Please ask for: Ms Iqraa Malik
Email: iqraa.malik@terraquest.co.uk
Telephone: 0121 234 1390
Our Ref: BR/229/21/HH
Your Ref:
Date: 1st October 2021

Application for Planning Permission for Works or Extension to a Dwelling

Development: Hip to gable roof extension with 2 x front dormers and installation of crossover
Location: 25 Pevensey Road Bognor Regis PO21 5NS

DRAWING TITLE
PROPOSED FIRST FLOOR PLAN

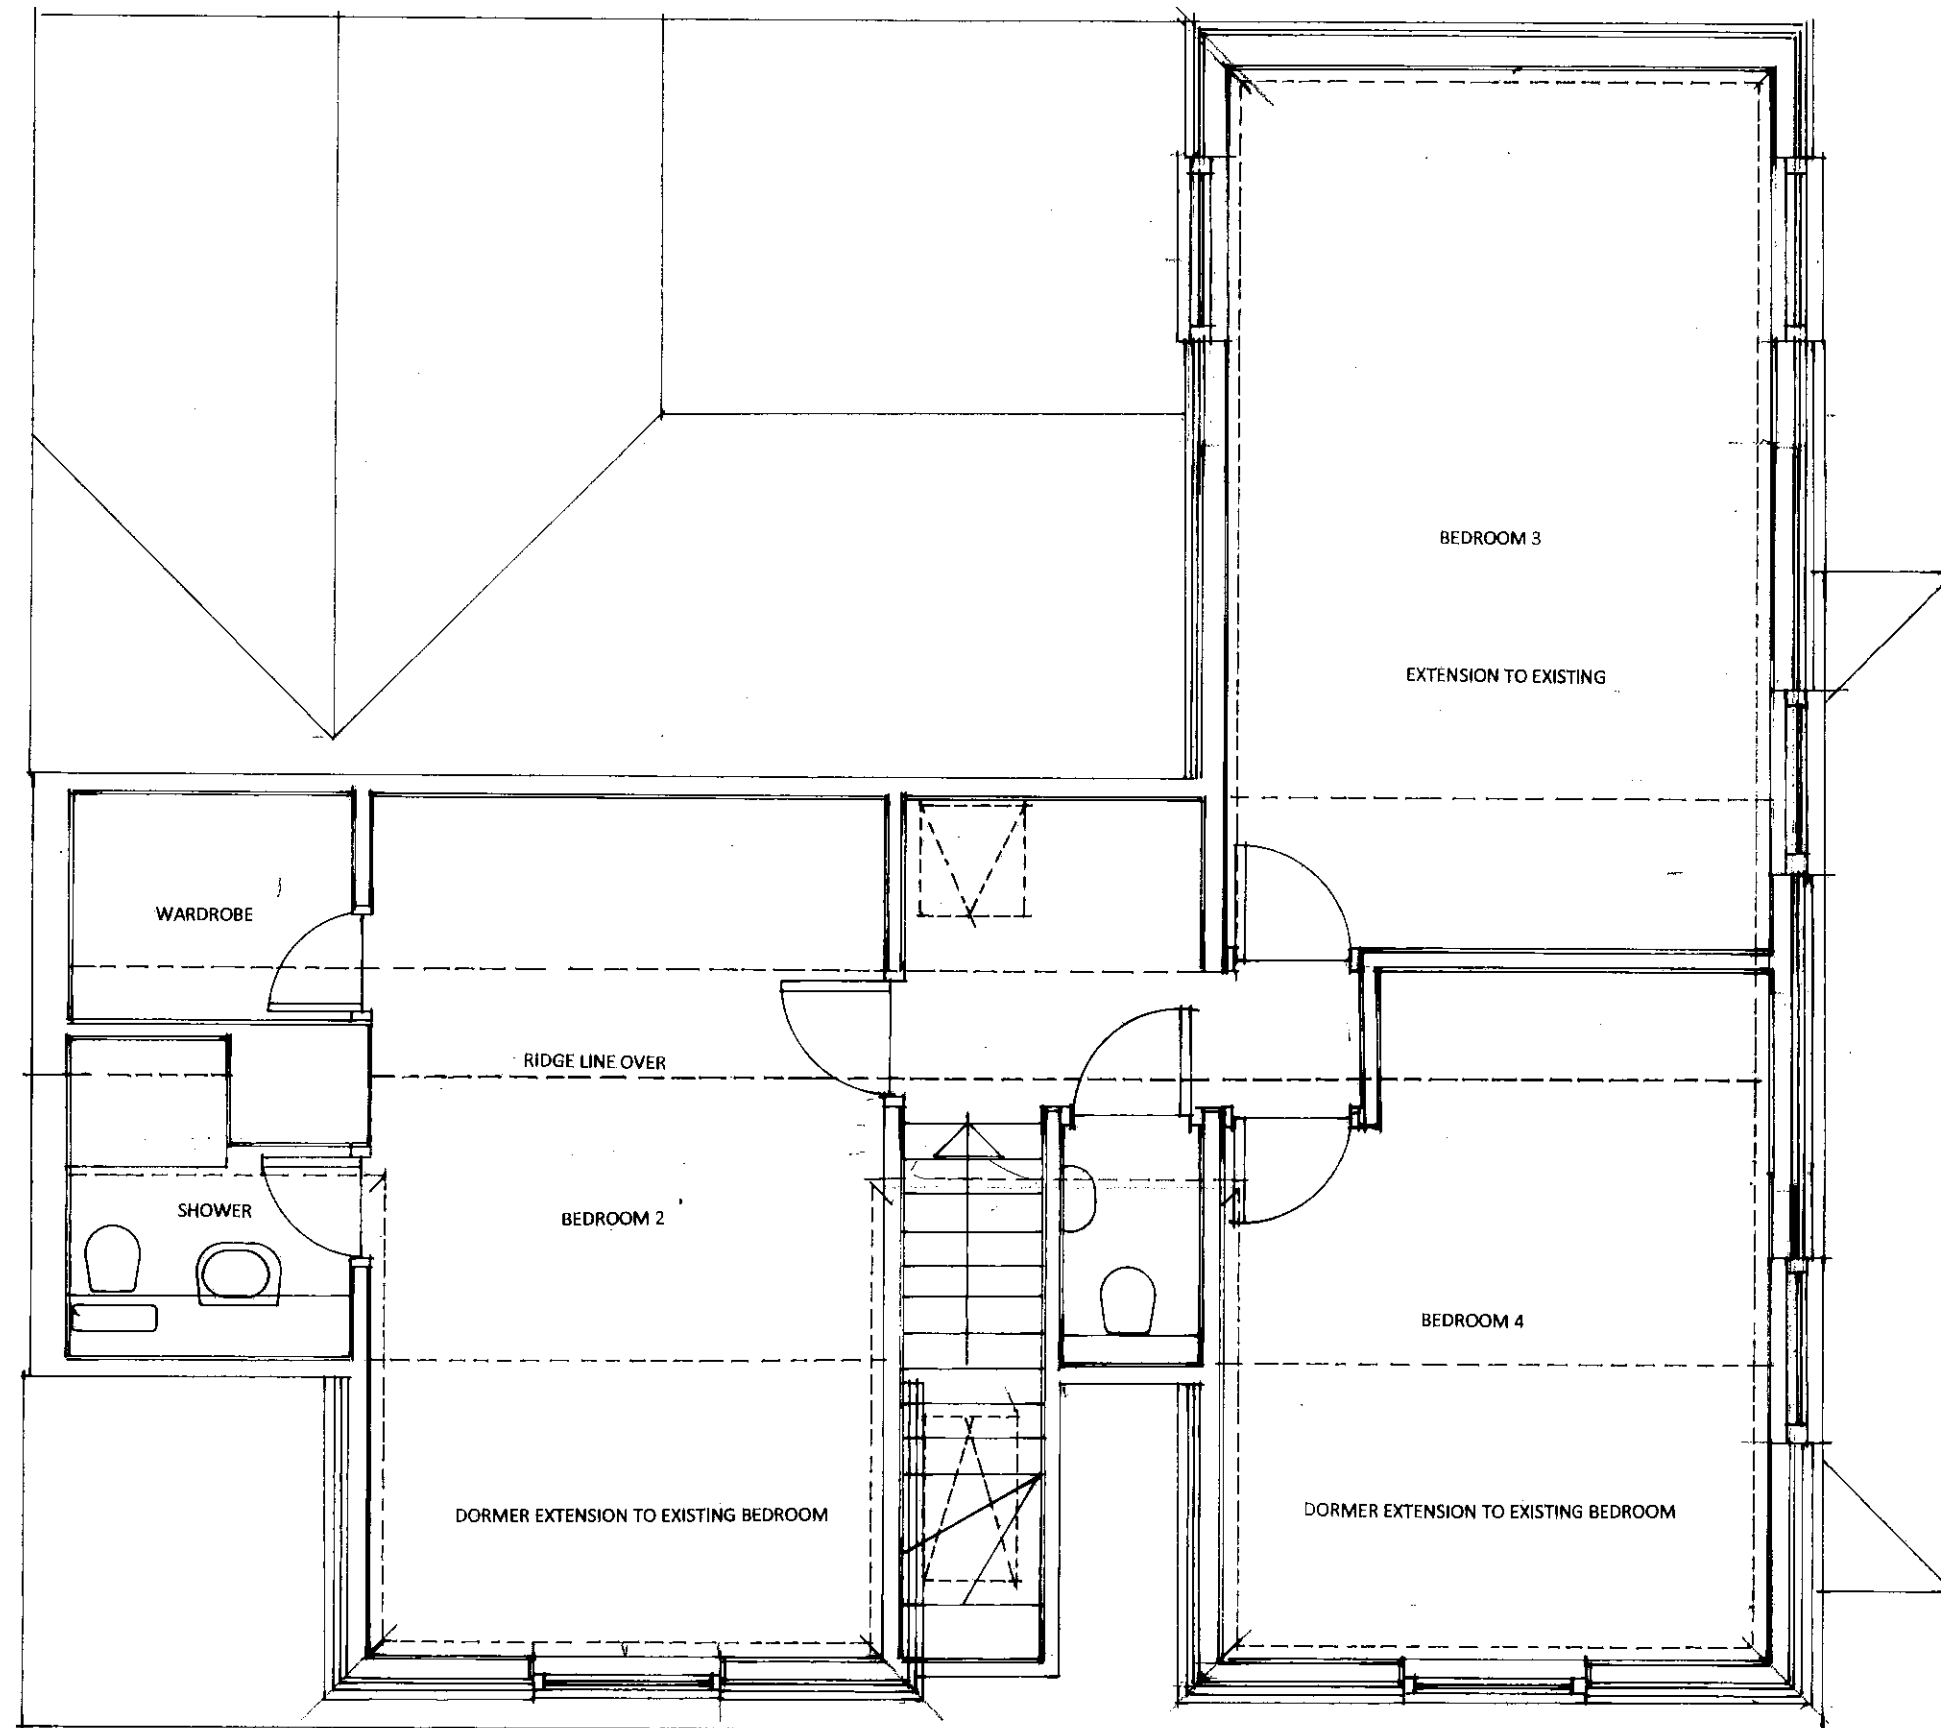
The windows on the proposed first floor plan is missing from the proposed south elevation. Please amend.

The windows on the proposed east/south elevation are inconsistent with the proposed first floor plan

FRONTAGE PARKING AND CROSSOVER

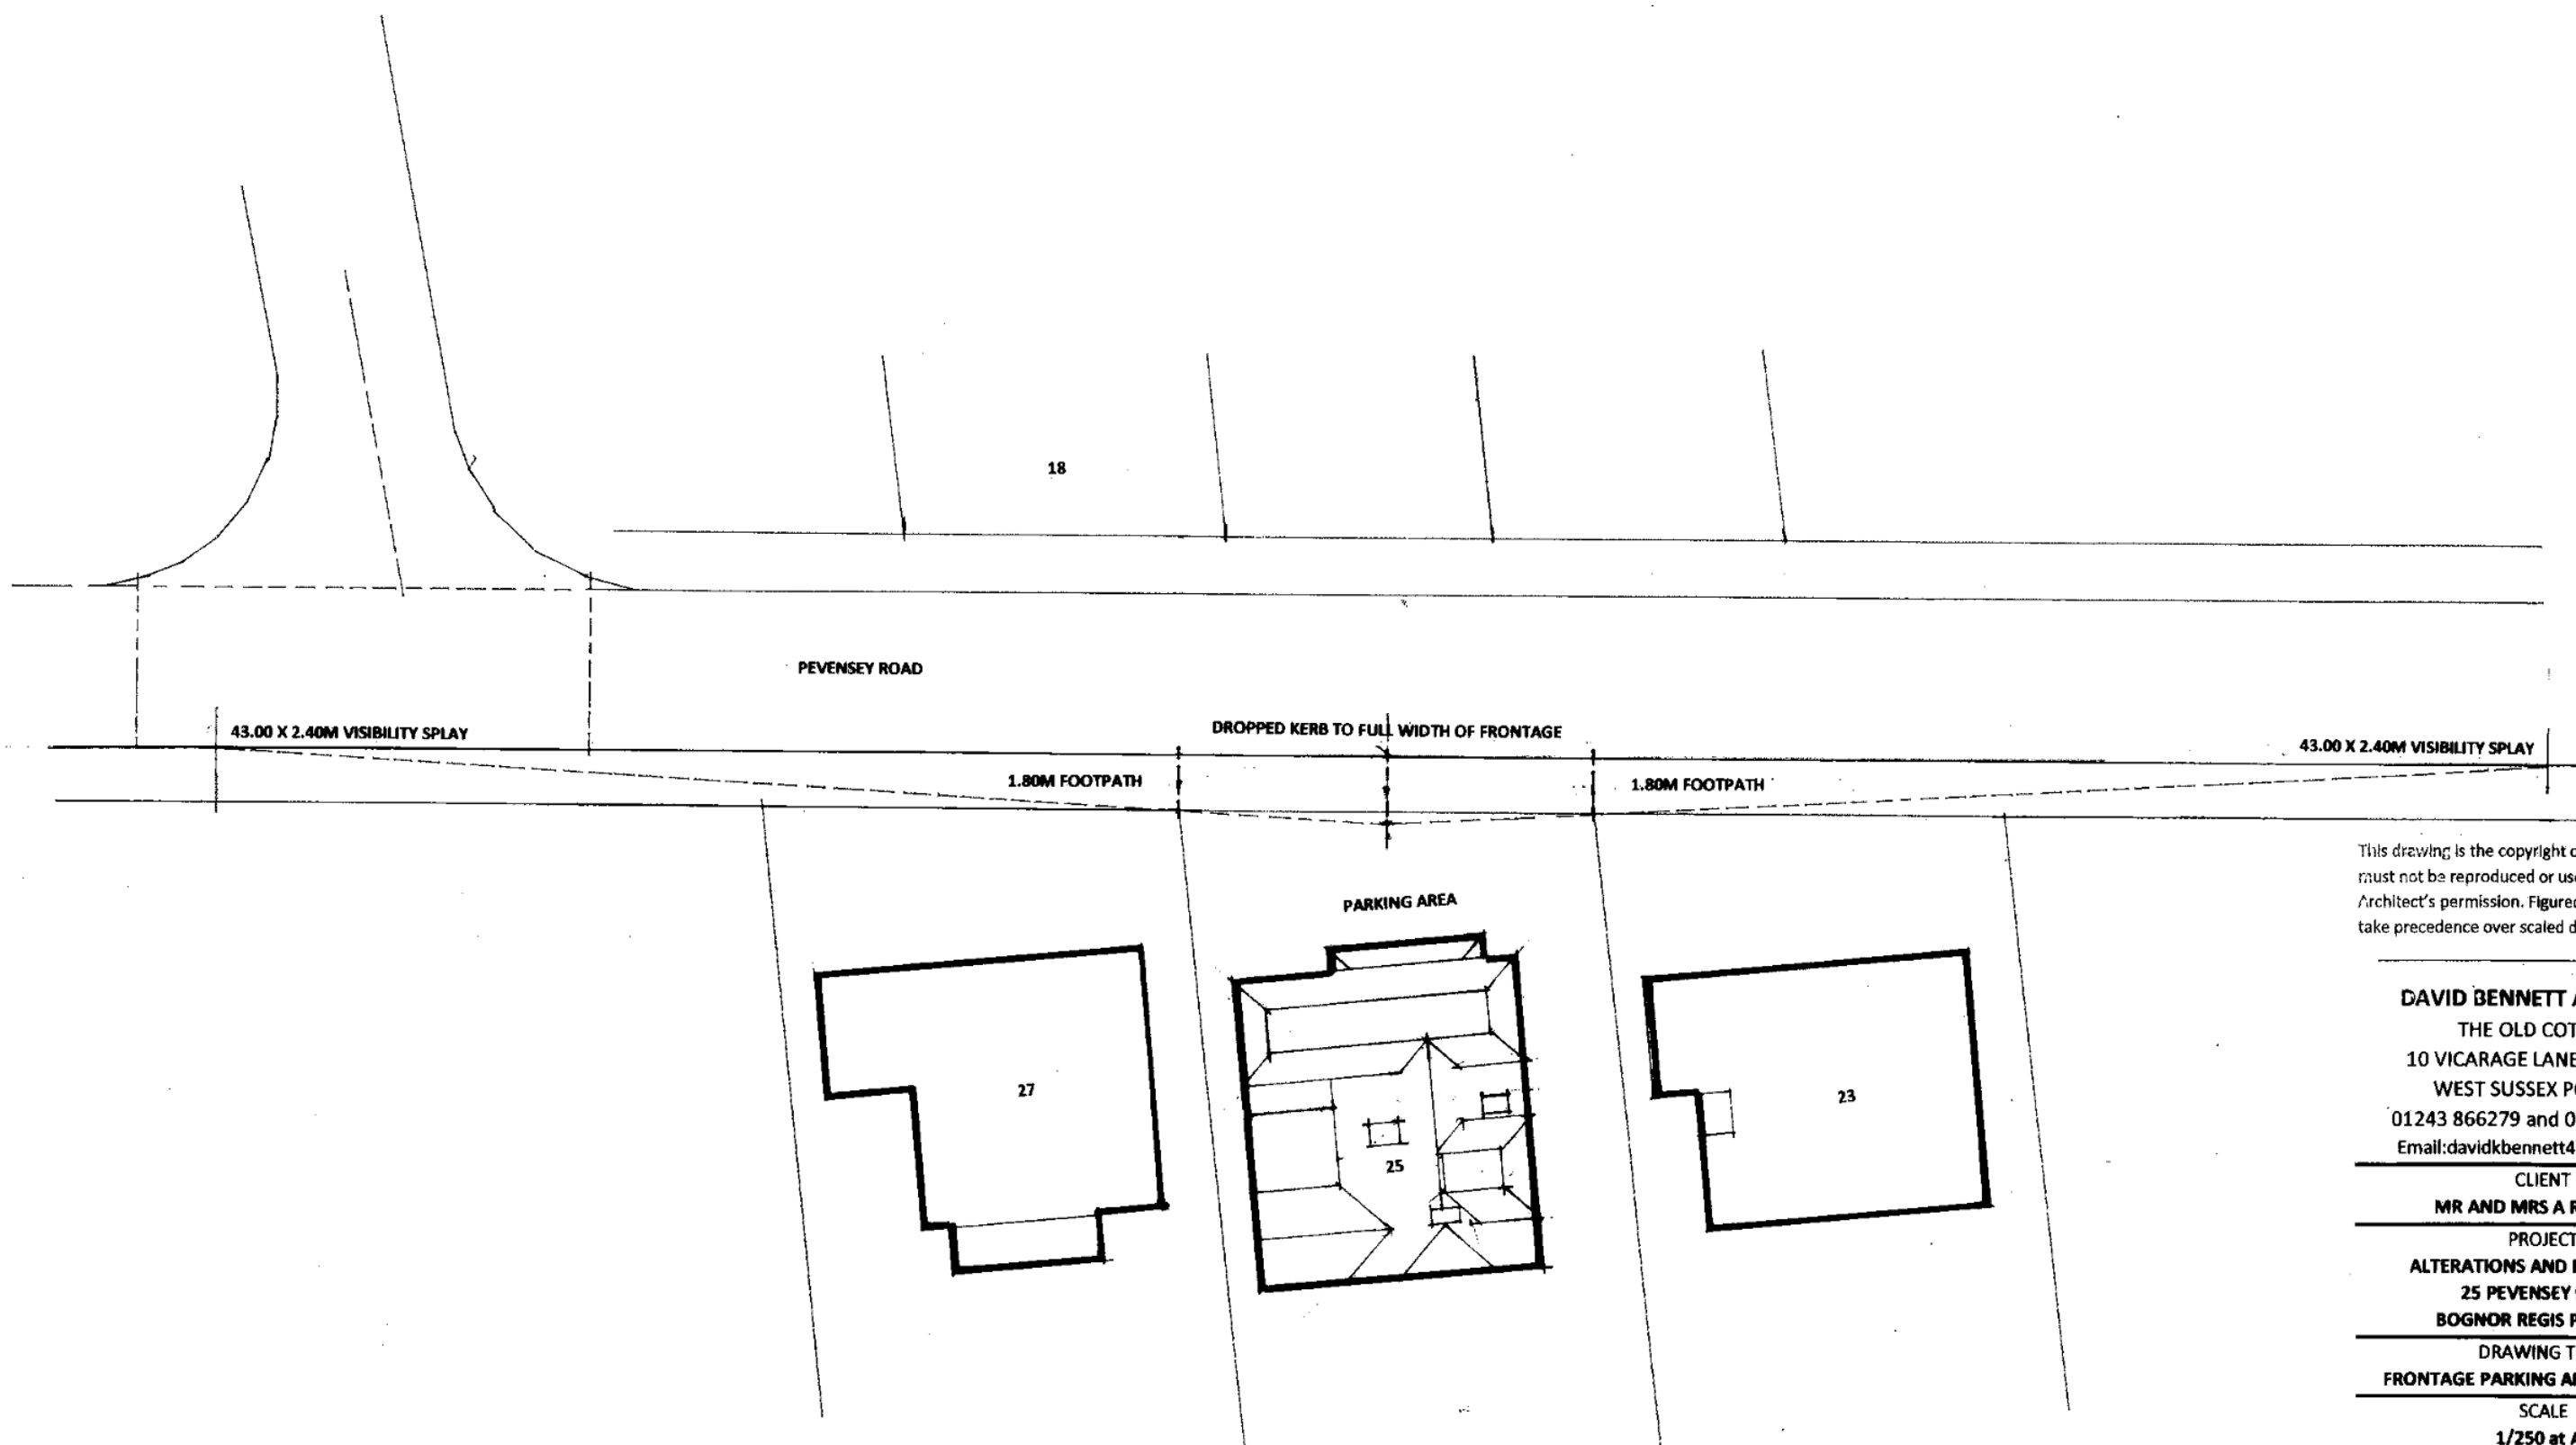
West Sussex County Council require that a visibility splay is provided. A splay is formed for a 30 mph speed limit road by measuring from a point 2.4m back from the kerb edge in the centre of the proposed access. A line should then be drawn from either side of this point for 43 m in each direction to the nearside edge of the carriage way. The splays must intersect and only within the control of the applicant, or within the publicly maintained highway.

You are required to submit a scaled plan of the crossover showing the width and depth of the proposed crossover.
